Jeanie Bourke - FW: The Inn at Diamond Cove - permit review

From: Barry Yudaken [mailto:yudaken@archetypepa.com]
Sent: Monday, April 15, 2013 12:06 PM
To: David Lloyd; Susan Geffers
Subject: The Inn at Diamond Cove - permit review

CBL: 083E E4600 **Permit ID:** 2013-00436

4/10/2013-JMB/Building:

A3.20

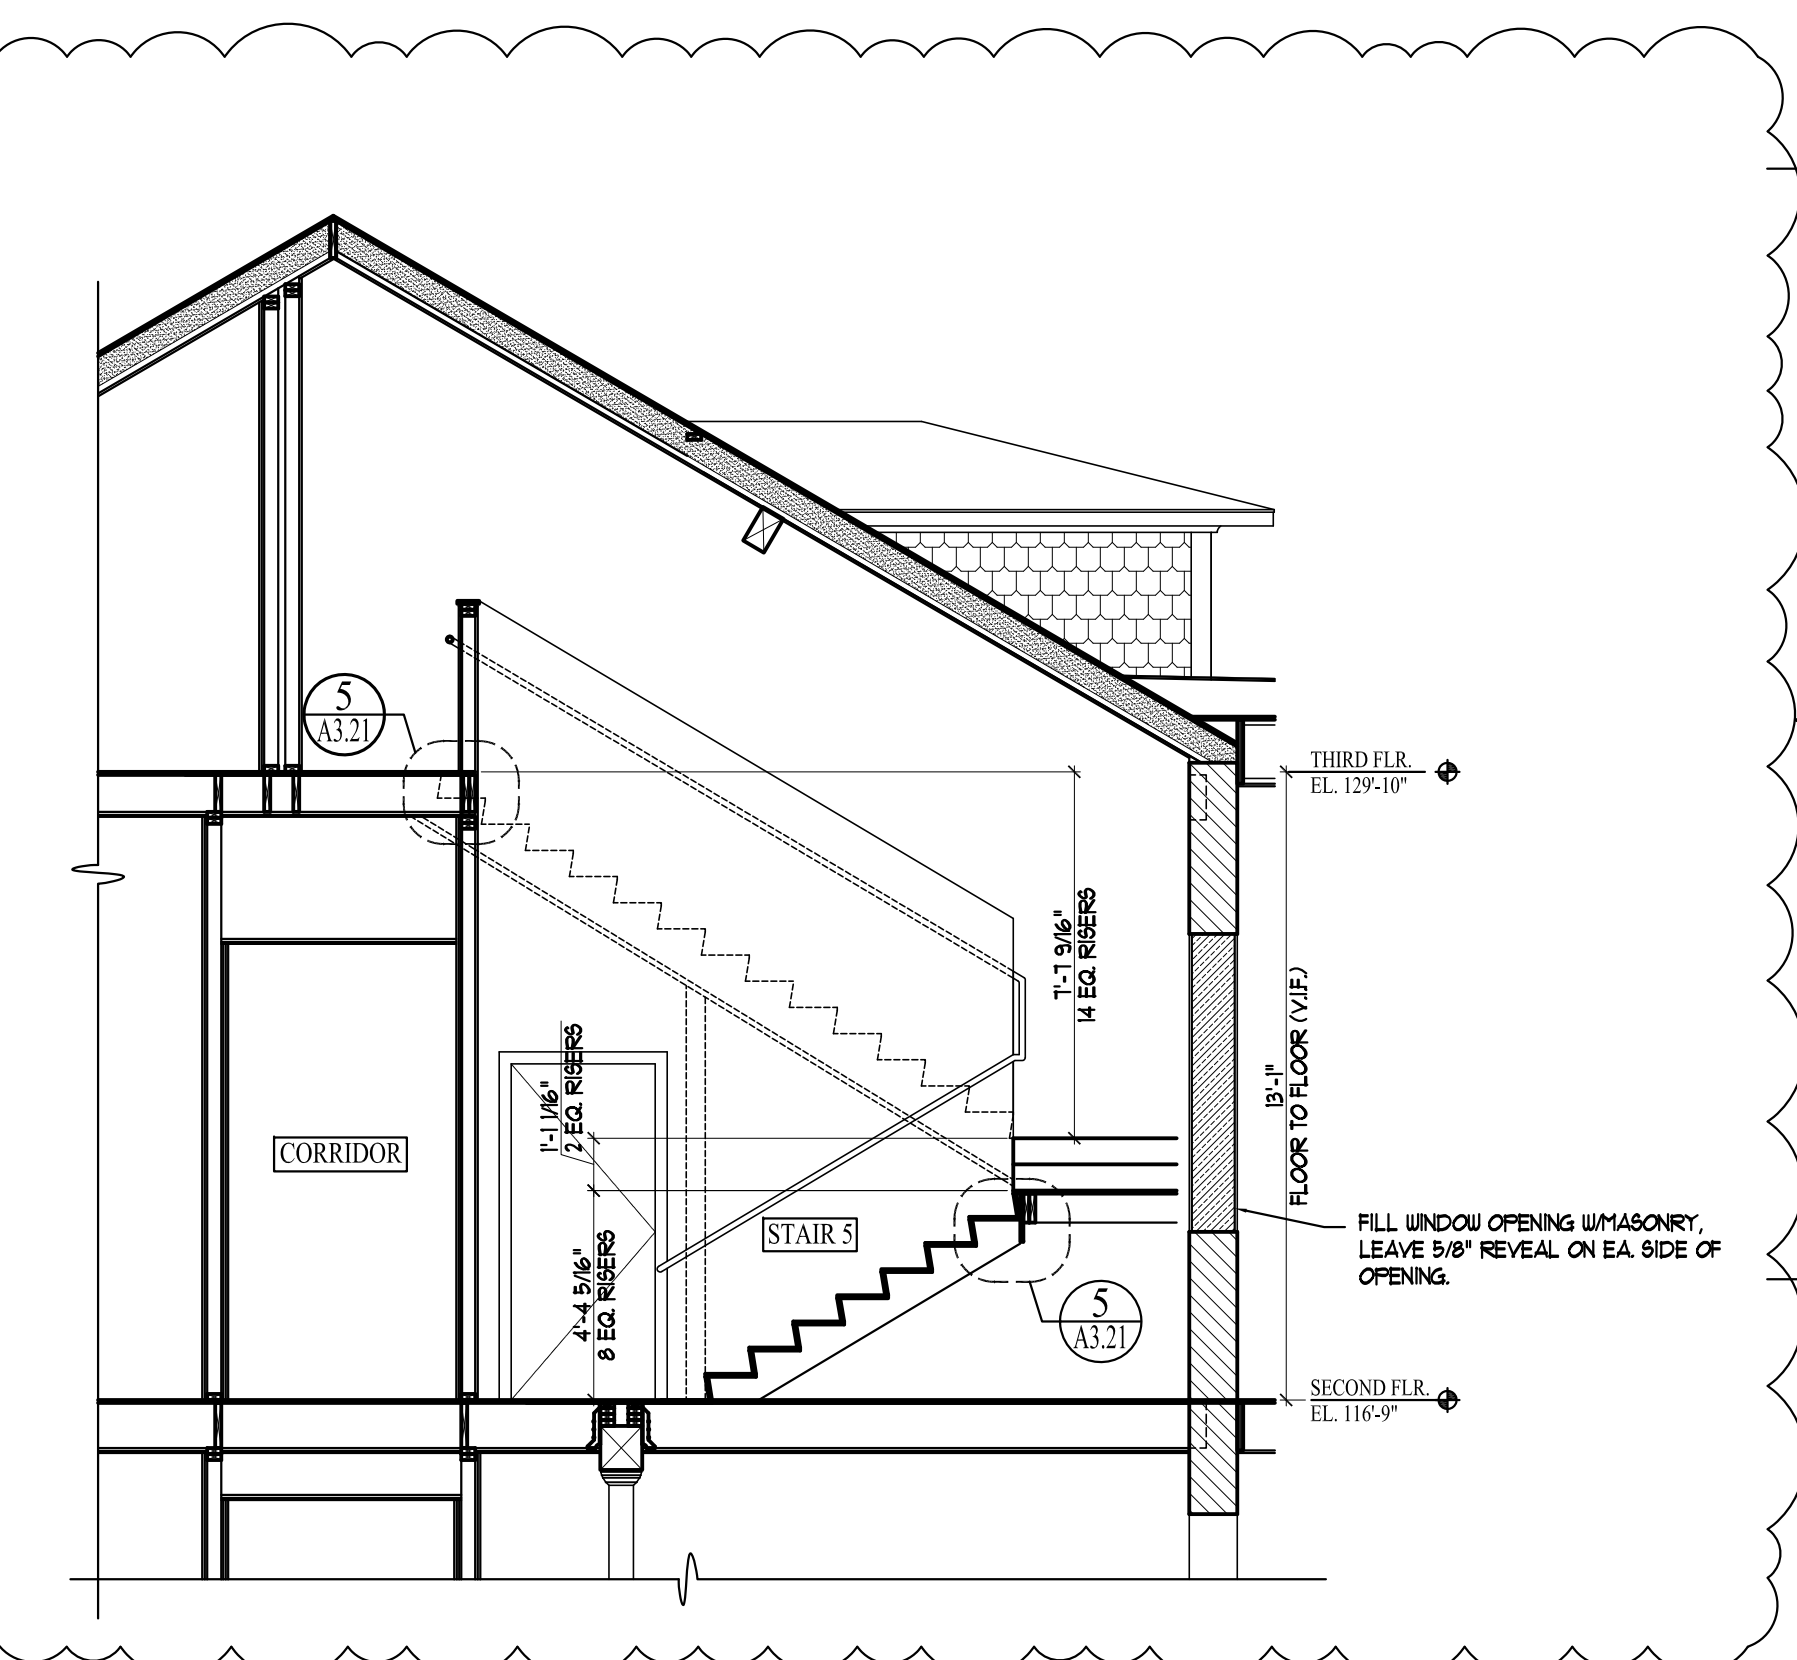
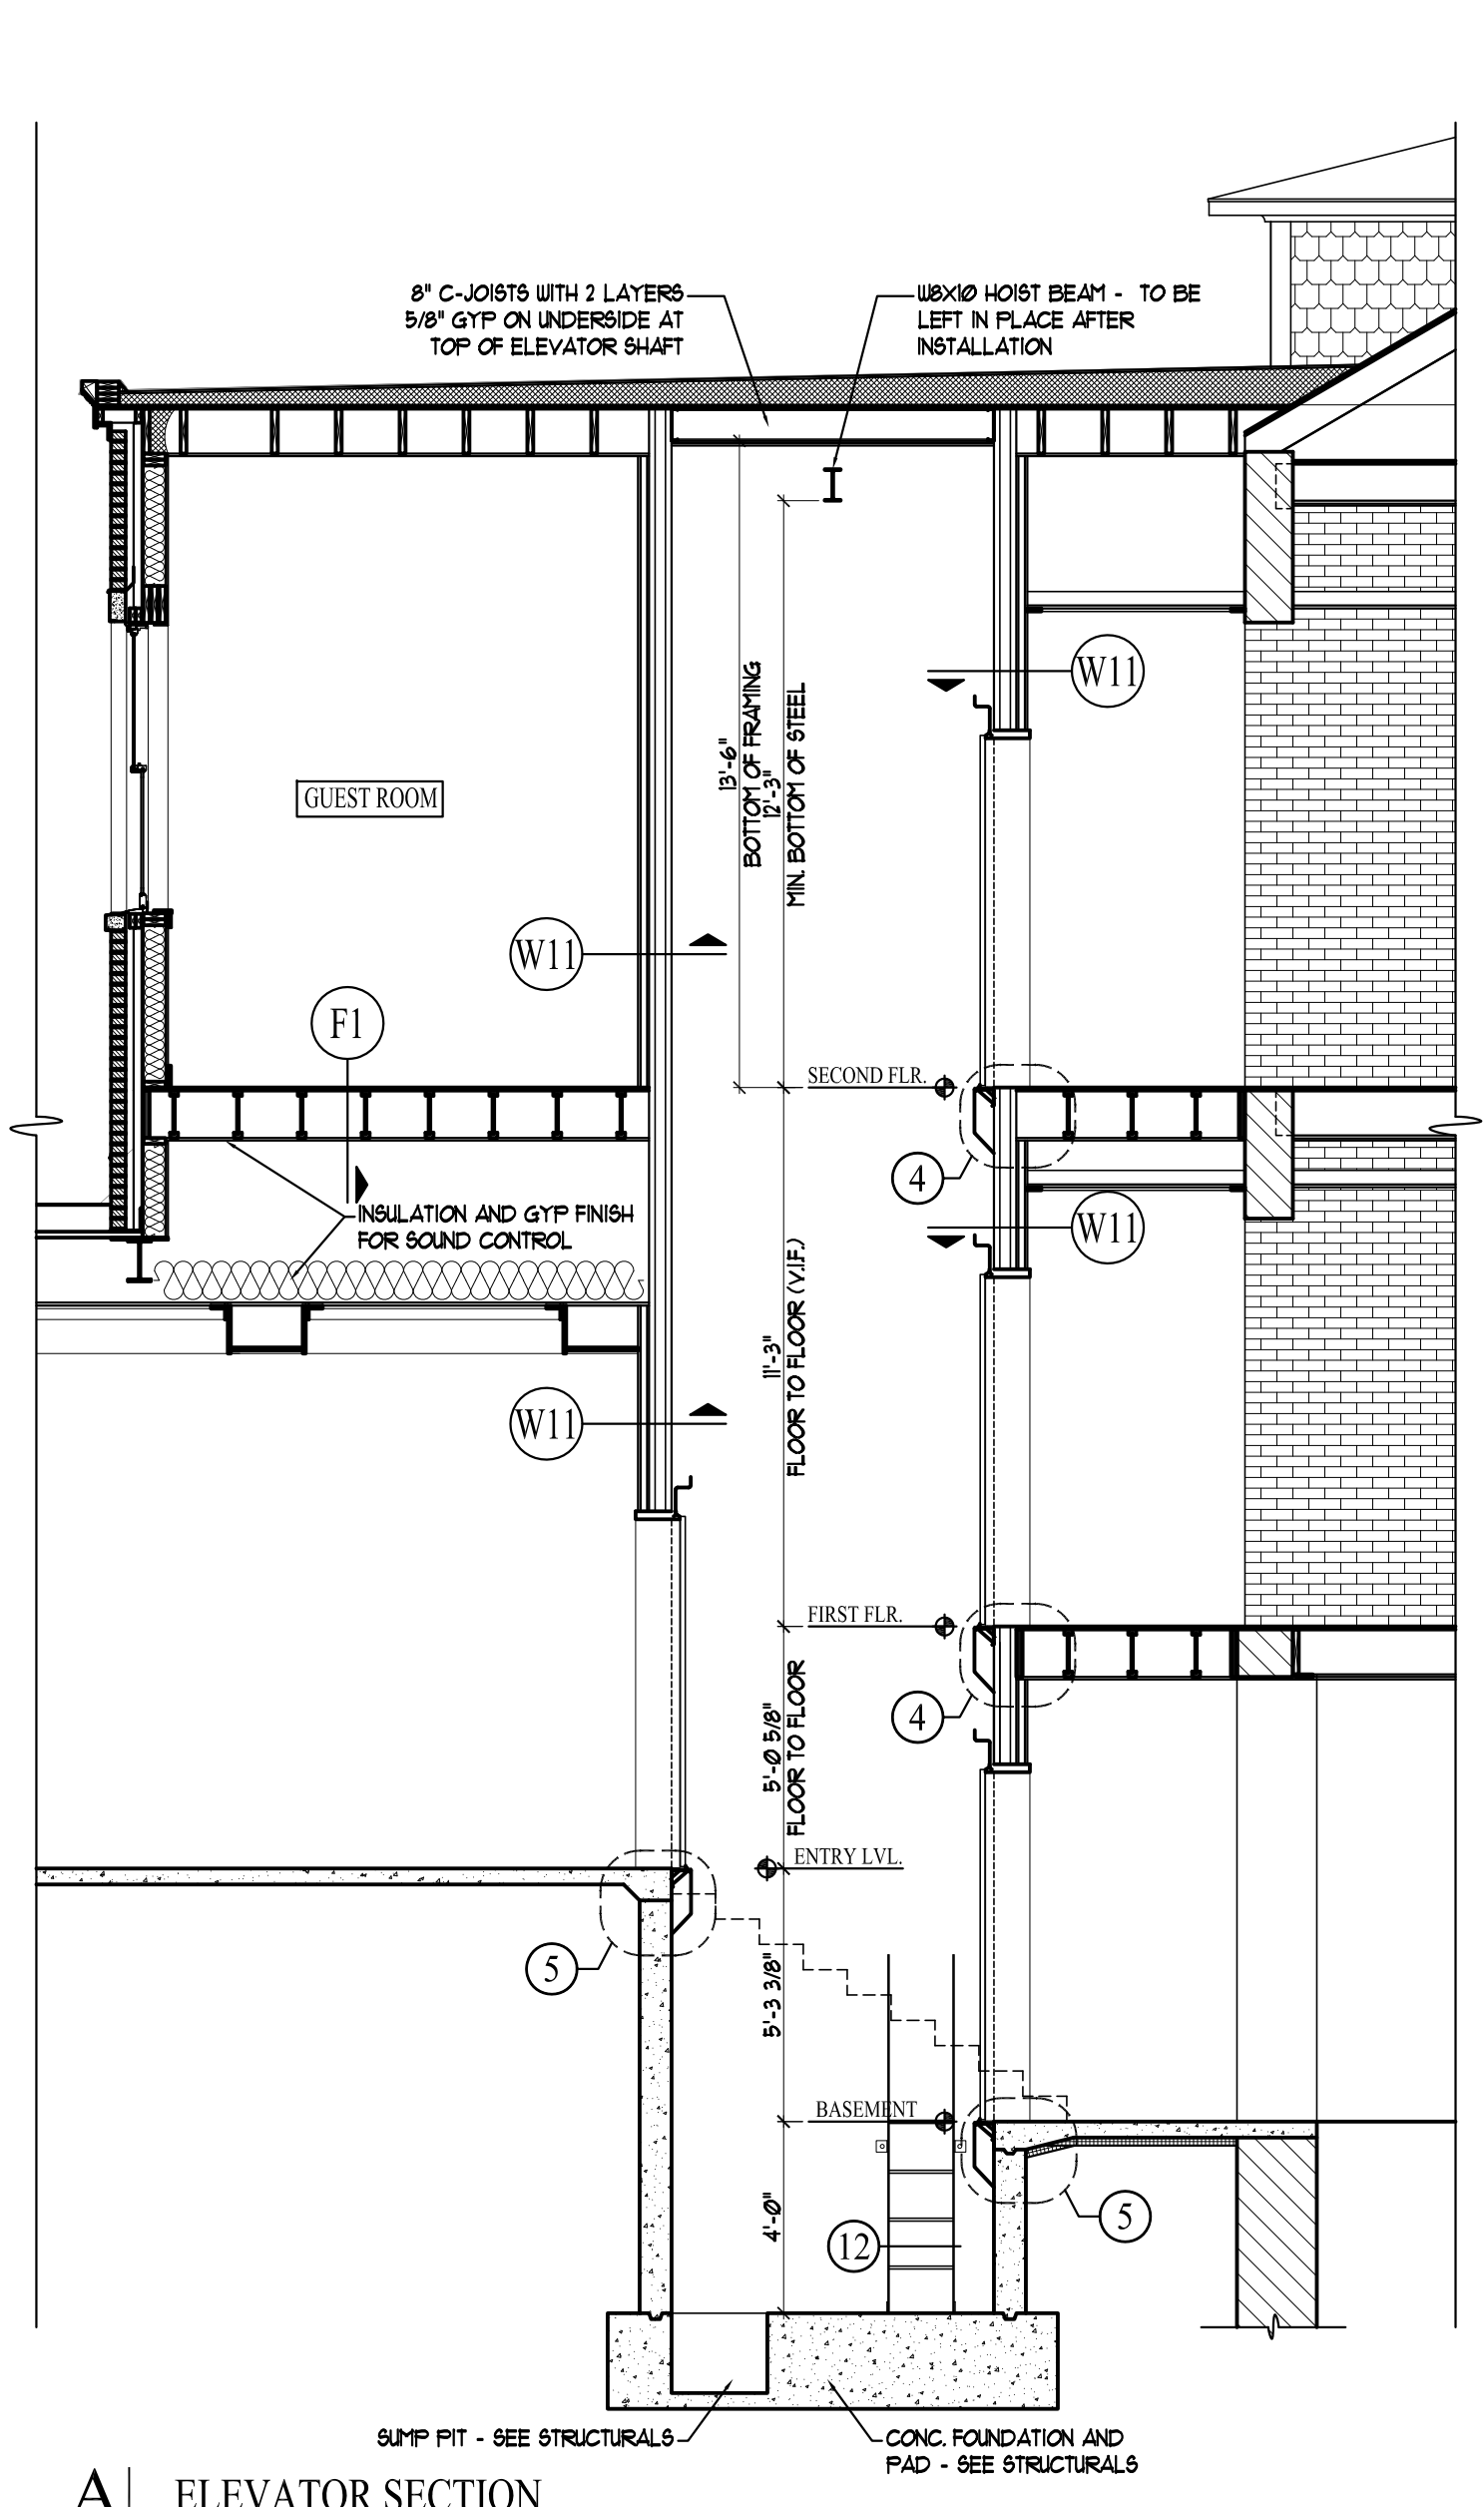
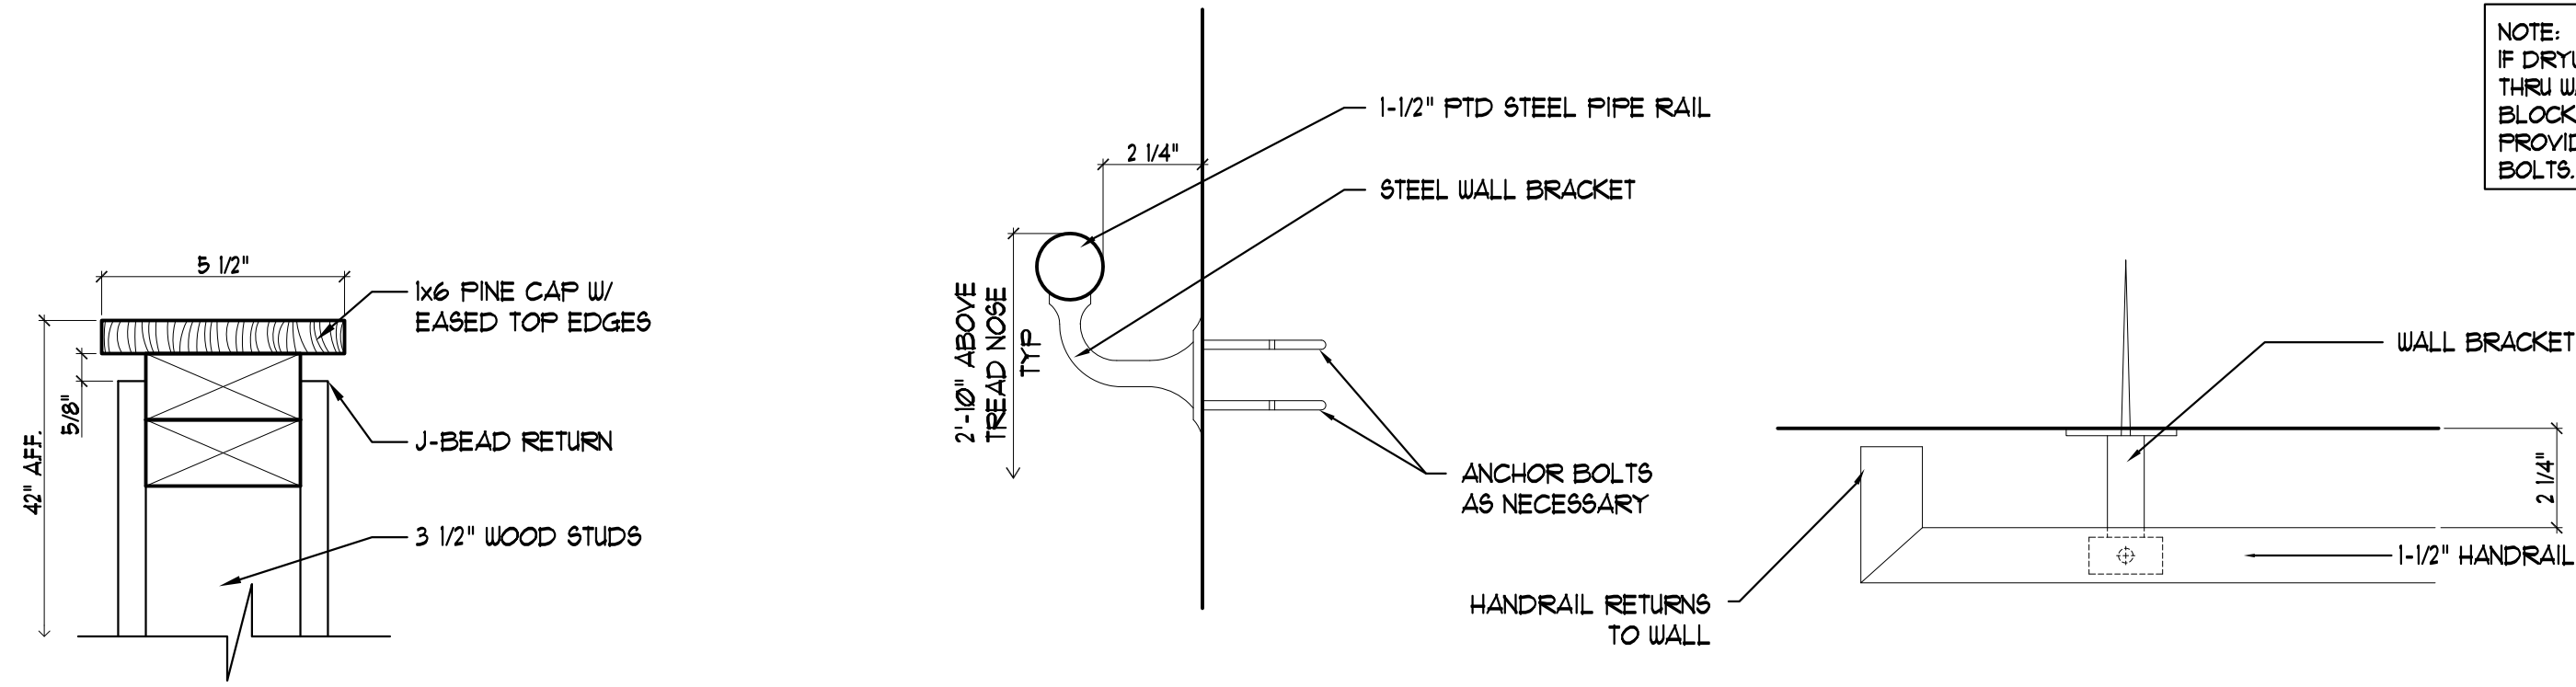
11. Plan A3.20 - Clarify wall types for partitions at stair #5, door #63 is 1 hour rated but the partitions aren't **noted on detail 8 and 9 A3.20 as one hour**

12. Plan A3.20 - Provide stair section C for stair #2 **shown above plan on drawing but see revised drawing A3.20**
13. Plan A7.02 - Provide stair dimensional details for the individual sleeping units, note Sec. 1009.4.2.5 does include R-1 in the exception **see revised drawing A7.02**

WINDOW SCHEDULE  
SCALE: 1/4" = 1'-0"

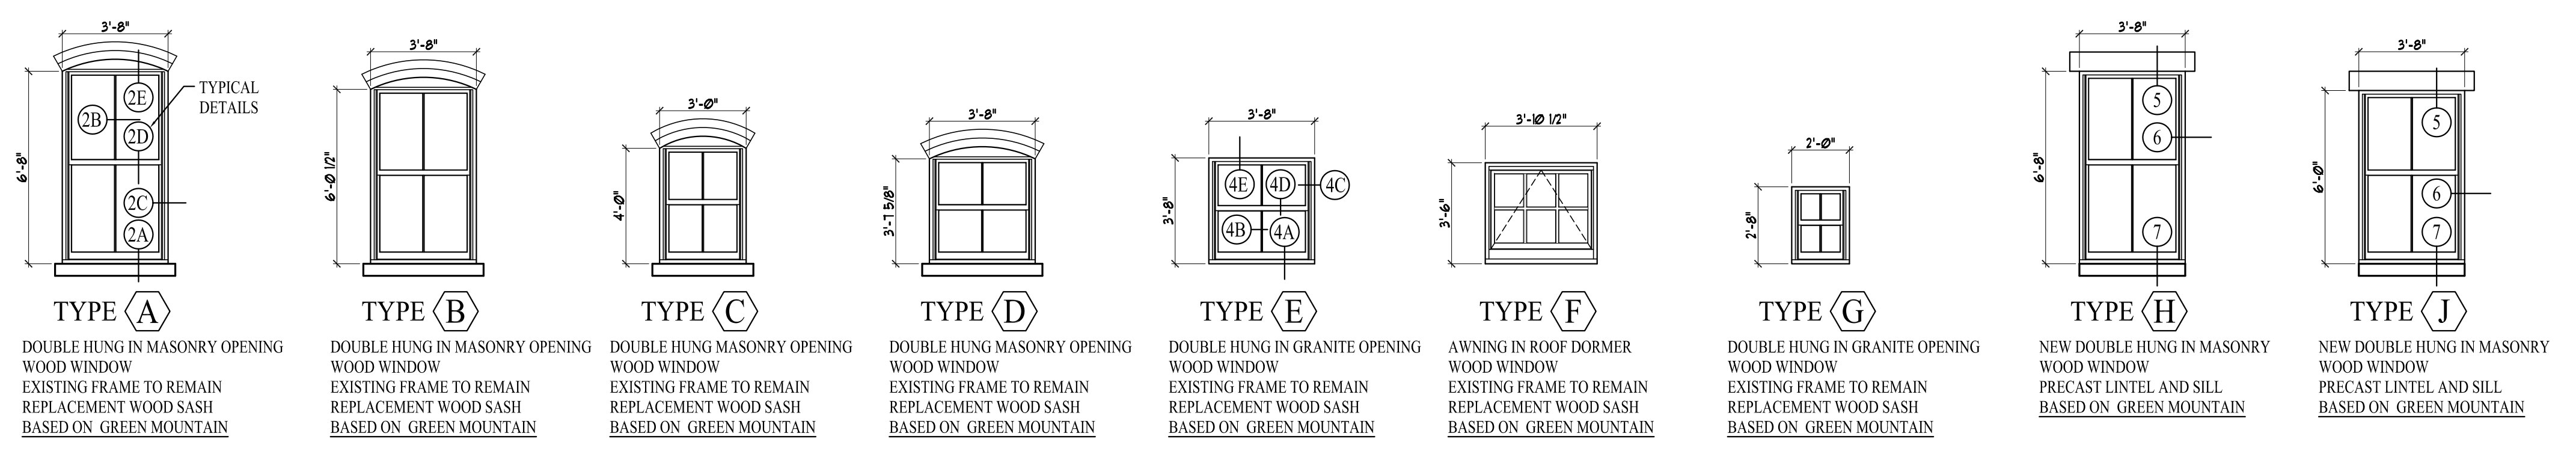
5. Provide tempered window locations per Sec. 2406, **See revised Window Schedule drawing A5.10**
6. Plan A3.10 - wall section - justify the thermal break at the exterior foundation wall from the rigid insulation at grade to the wood framed wall **I don't understand what the problem is with this detail**
